From: Lauren Griffin
Sent: Monday 2 December 2024 11:52
To: eamonos@tpa.ie
Subject: RE: Response to ABP Request 8/11/24 - Letter (ABP Ref. 318683)

ABP Ref. 318683

Re: RESPONSE TO AN BORD PLEANALA REQUEST DATED 8 NOVEMBER 2024

Starrus Eco Holdings Ltd (SEHL) has retained Tom Phillips + Associates (TPA) to prepare this First-Party Submission in response to a letter issued by An Bord Pleanála (ABP) inviting TPA to comment on observations submitted on a Strategic Infrastructure Development (SID) application located at Panda Waste, Ballymount Road Upper, Ballymount, Dublin 24, D24 E097.

02- ESB SUBSTATION ROOF PLAN
SCALE 1:100

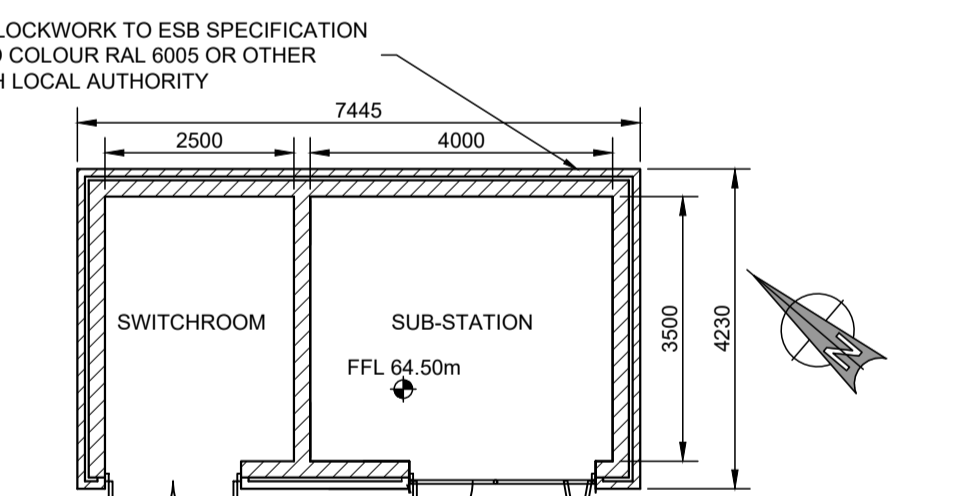
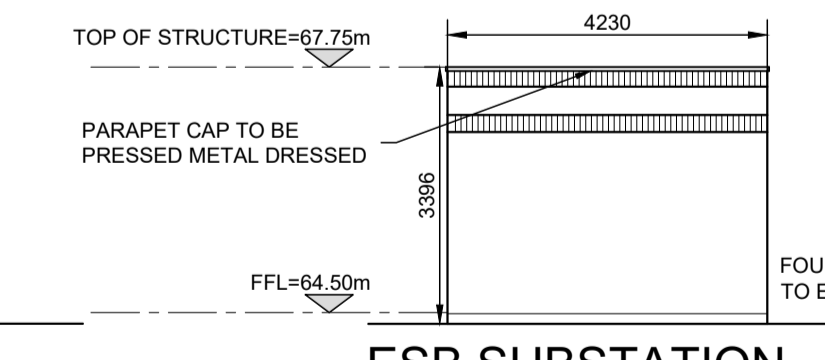
7. *This permission is for a period of 5 years from the date of this grant of planning permission. The telecommunications structure and related ancillary structures shall then be removed unless, prior to the end of the period, planning permission shall have been granted for their retention for a further period by the Planning Authority or by An Bord Pleanála on appeal.*

Reason(a): To enable the impact of the development to be reassessed, having regard to advances in technology and design of radio equipment and antennae, changes in the design of support structures, more stringent or other standards, if considered more appropriate, during the period of five years and to circumstances then prevailing. Monitoring to determine the adherence to the guidelines of the International Non-ionising Radiation Committee of the International Radiological Protection Association, under the auspices of the WHO and the European Pre standard RNV 50166-2 Human Exposure to Magnetic Fields-High Frequency (10KHz to 300GHz) promulgated by CENELEC, the European Committee for Electro technical standardization shall be made immediately before the site is brought into commission and thereafter at yearly intervals by a competent authority, using up-to-date monitoring equipment. The results of all monitoring shall be available for inspection by the Planning Authority and/or other appropriate body.

We note that SDCC propose a condition requiring the substation to be temporary in nature. We consider this proposed condition to be overly onerous and has the potential to impact on the future operation of the business. There should be no need to re-apply for the permitted infrastructure after a period of five years. The proposed condition is not justified nor is it

warranted. Furthermore, the condition suggests that the applicant will need to apply for 'retention permission', suggesting that the applicant will be seeking to carry out unlawful development. This is not the case.

The condition as worded would require a further grant of planning permission to be made to extend the life of the substation. This timeframe would start from the decision date of a grant of permission. If the permission takes 18 months to build, there would only be 3 ½ years operational value with the substation. Let alone the cost to build the structure for this 'temporary' period, should the applicant wish to extend the life of the substation they would need to apply for a new permission within 12 months of the structure being completed to allow time for planning authority review and potential appeal timeframe.

This proposed condition should not be imposed.
